Council Reference: D25/429779  
Contact Person: Justin Lamerton

SSD-3846-Mod-1  
Shoalhaven City Council Response to Request for Comments

I refer to the Department of Planning, Housing, and Infrastructure's request for comment in relation to the West Culburra Mixed Use Subdivision - Modification 1 - Realign development footprint over property at Culburra Rd, Culburra Beach (Lot DP 1305809).

Map 2.1 - Proposed activity in relation to archaeological potential

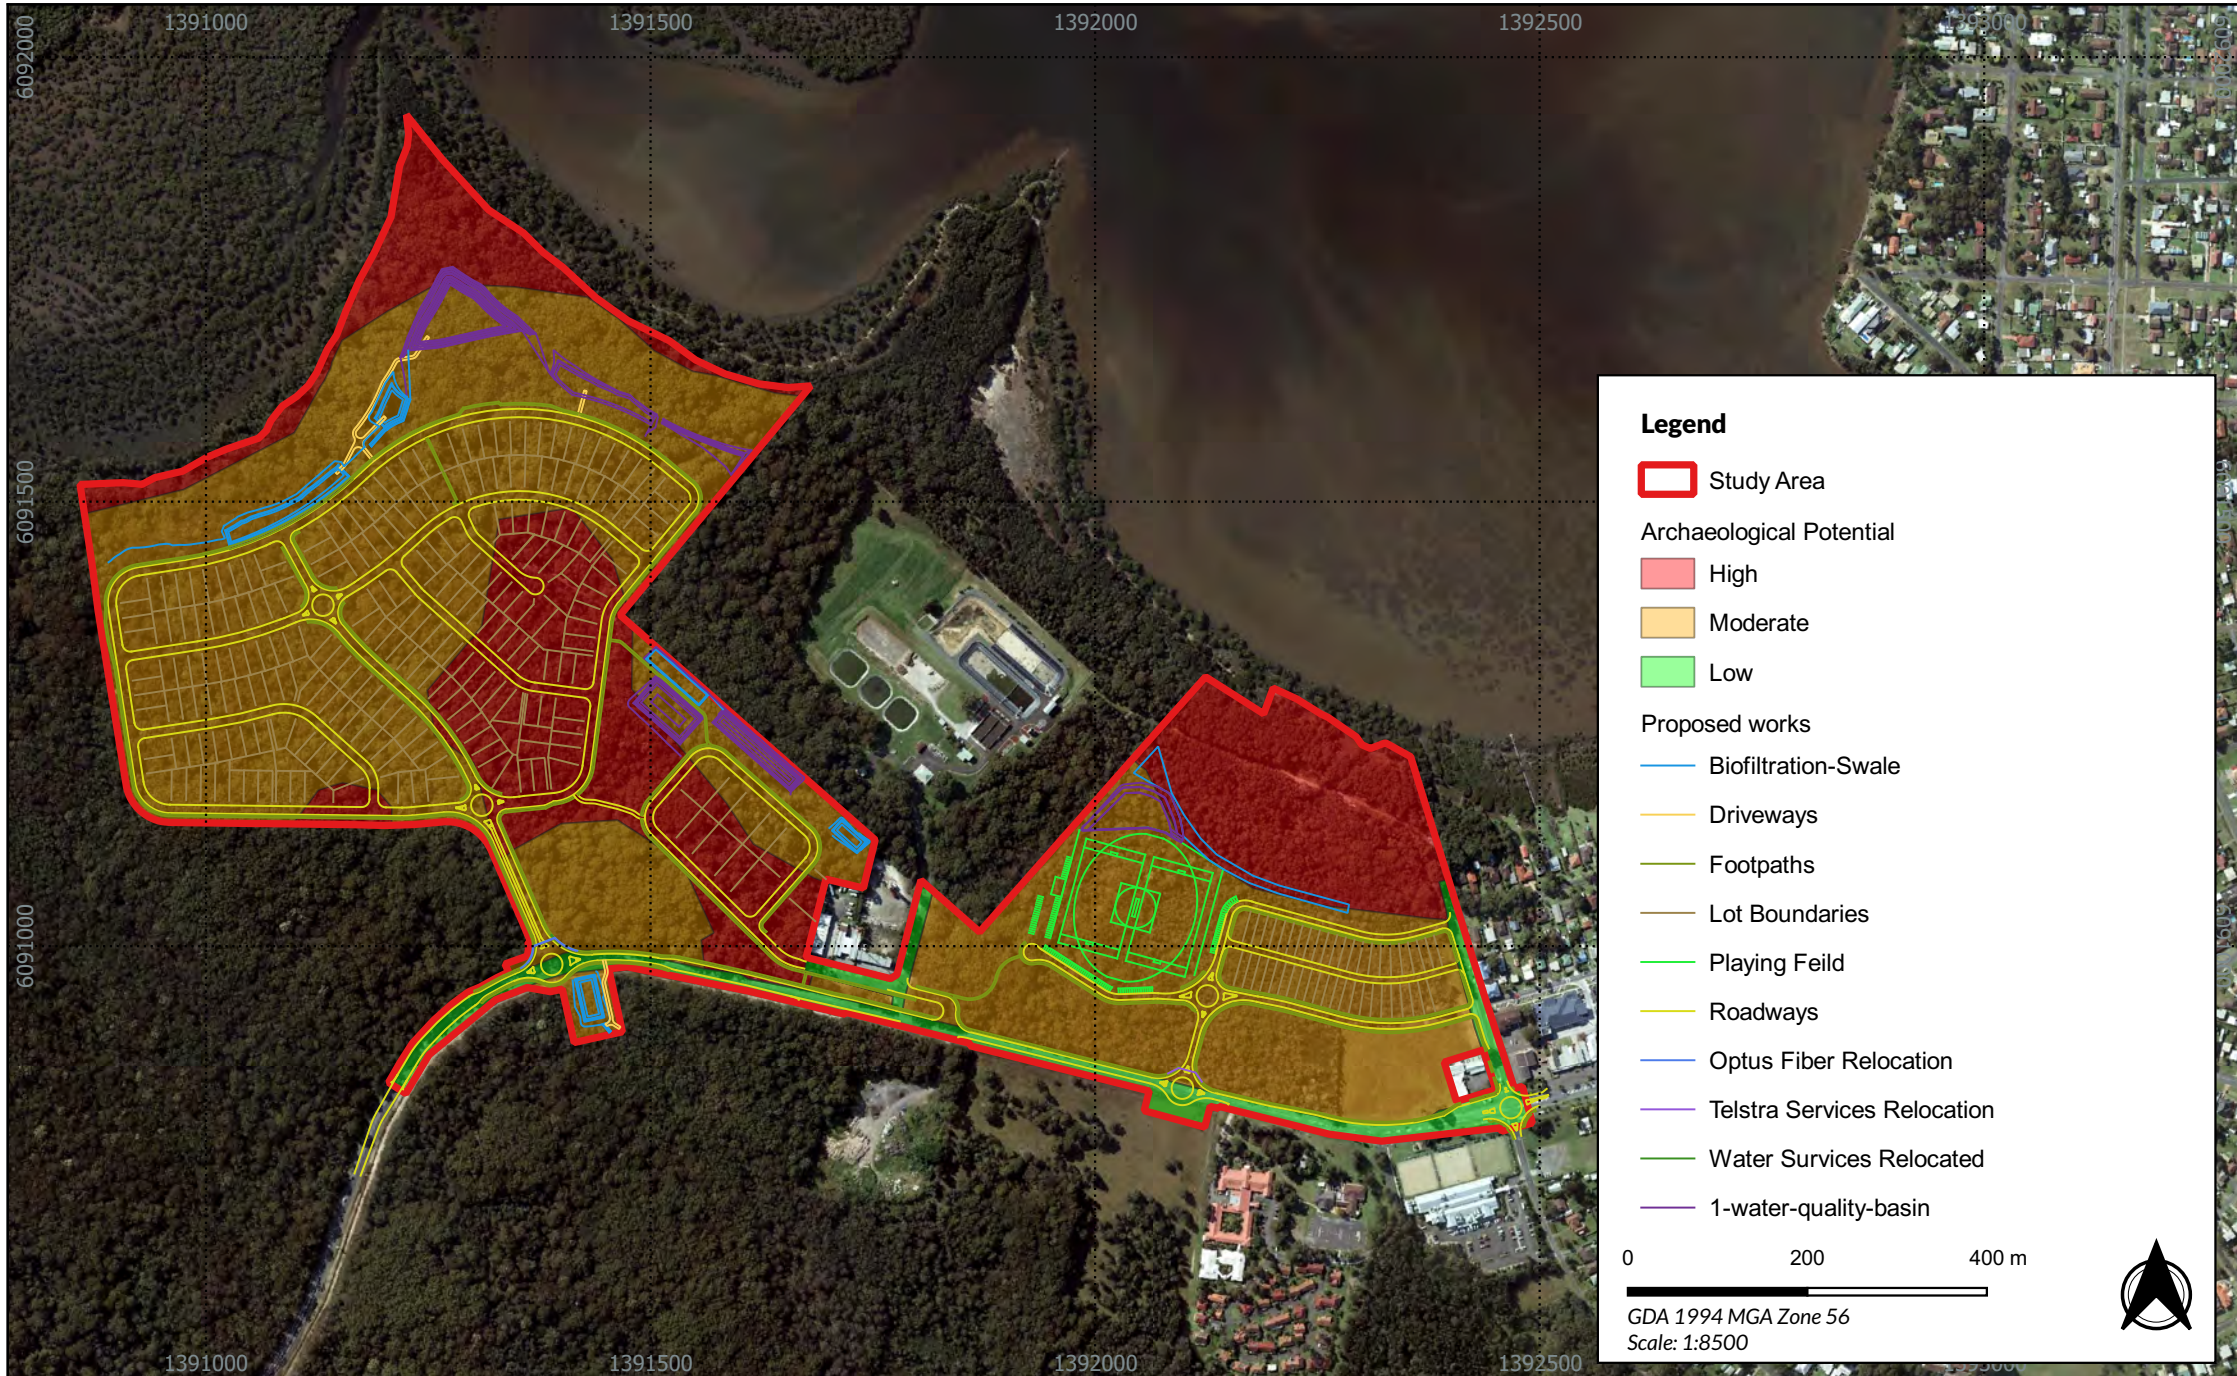
- The Aboriginal Cultural Heritage Assessment (Map 2.1) depicts a number of Artefacts within the area subject to the relocation and reduction of the overall development footprint. It should be ensured that the outcomes presented in the submitted Report are consistent with changes made to the approved layout.
